Please ask for: Ms Iqraa Malik
Email: iqraa.malik@terraquest.co.uk
Telephone: 01212341390
Our Ref: A/11/21/HH
Your Ref:
Date: 1st February 2021

Application for Planning Permission for Works or Extension to a Dwelling

Development: Minor exterior and interior alterations to Listed property. The work includes 3 x new windows, back elevation, demolition of an interior dividing wall, and other minor works.
Location: Waterton House Arundel Road Angmering BN16 4JR

GROUND FLOOR PLAN - Before and after, alterations highlighted

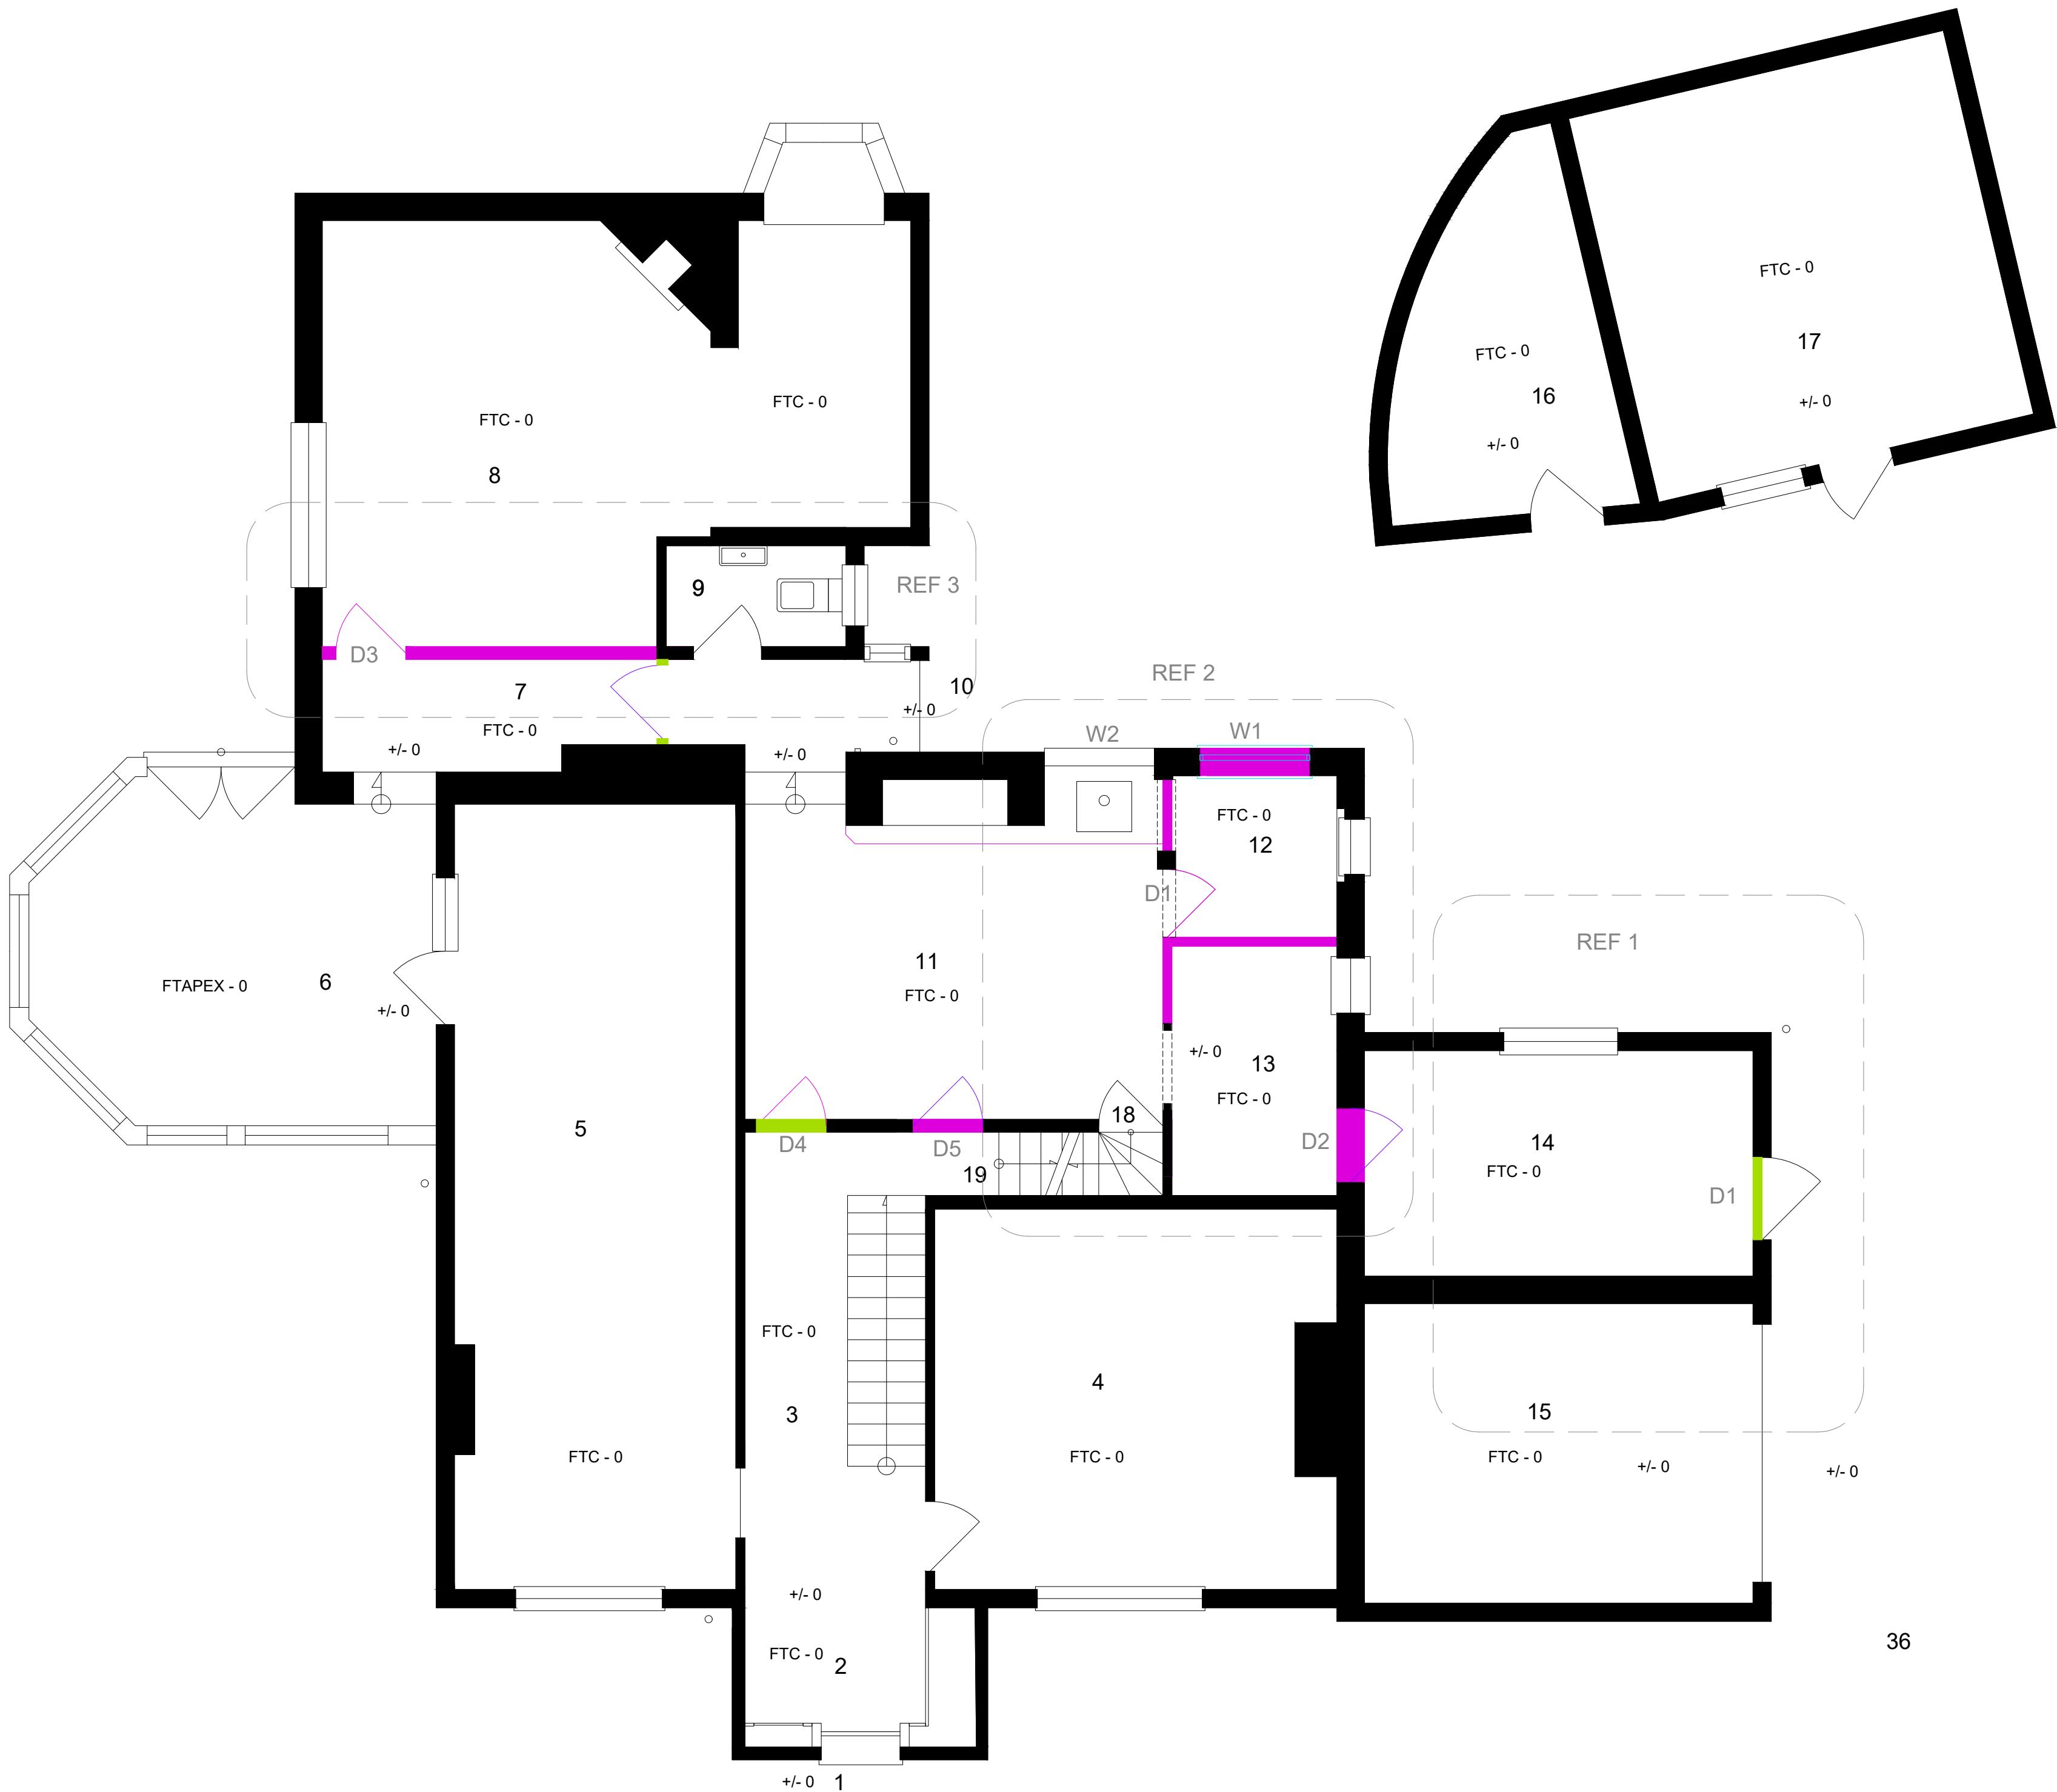
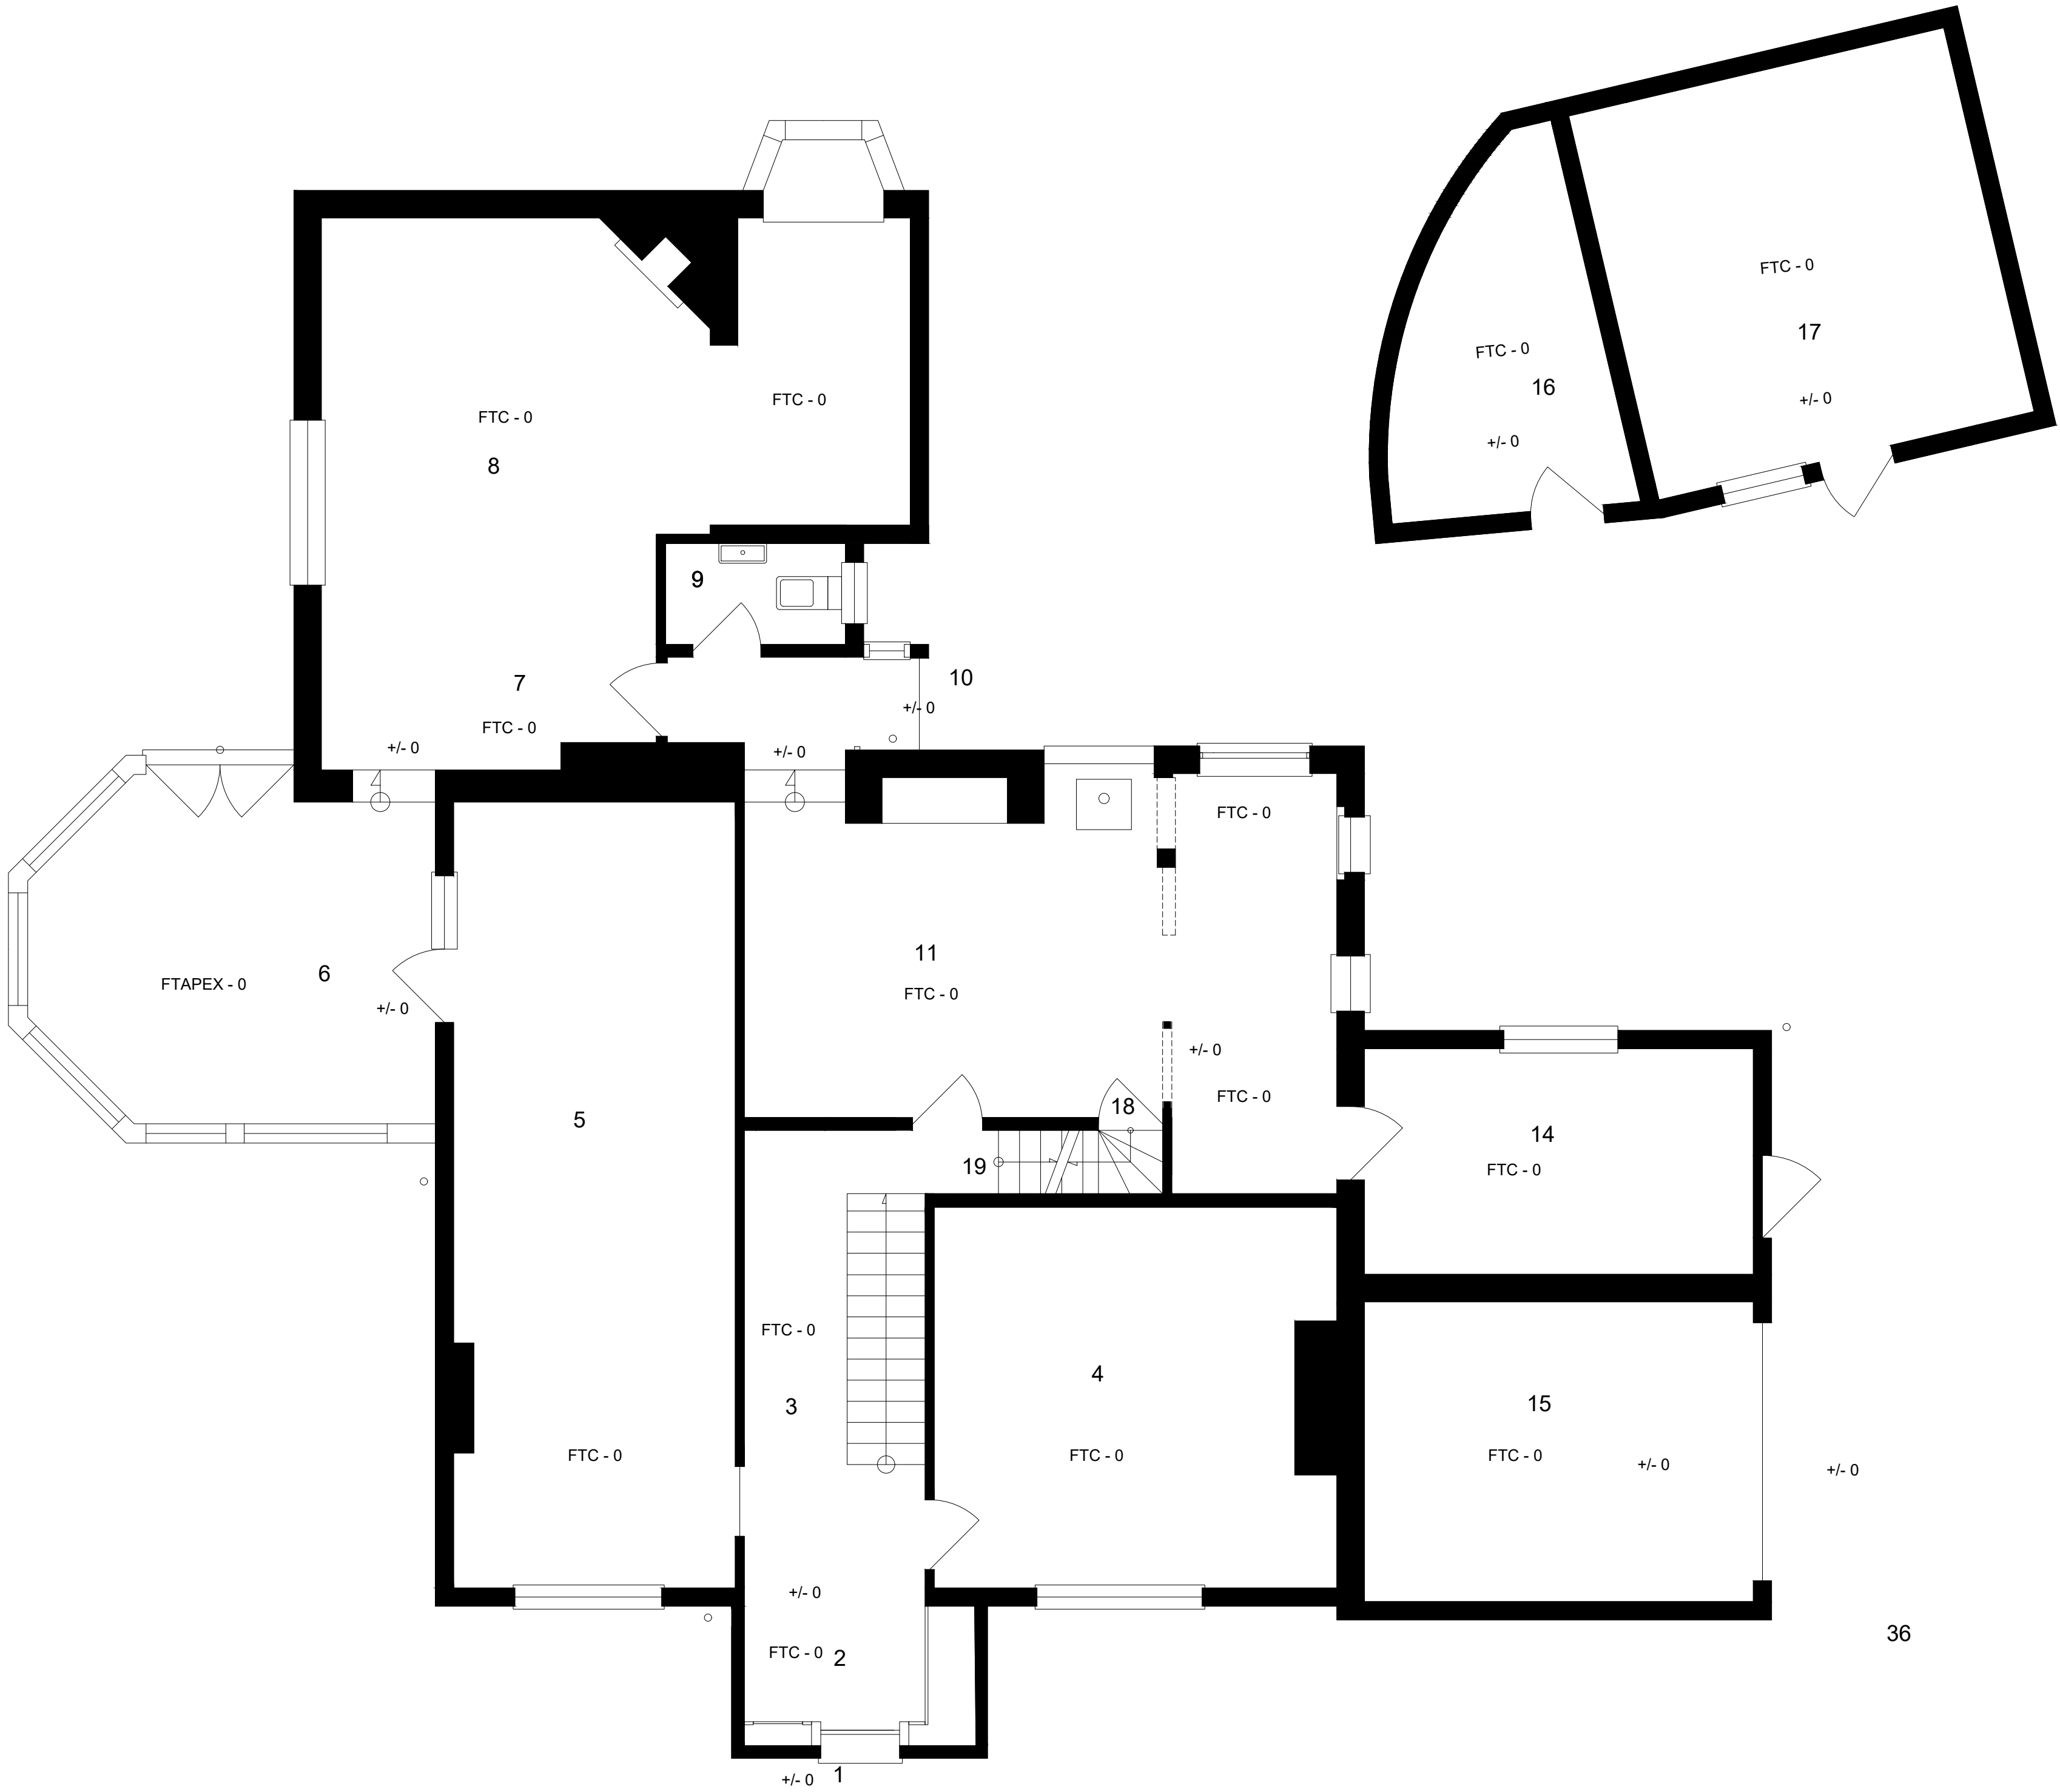
Windows: The application form states 3 windows however the plans are showing 2. Please confirm and amend as necessary
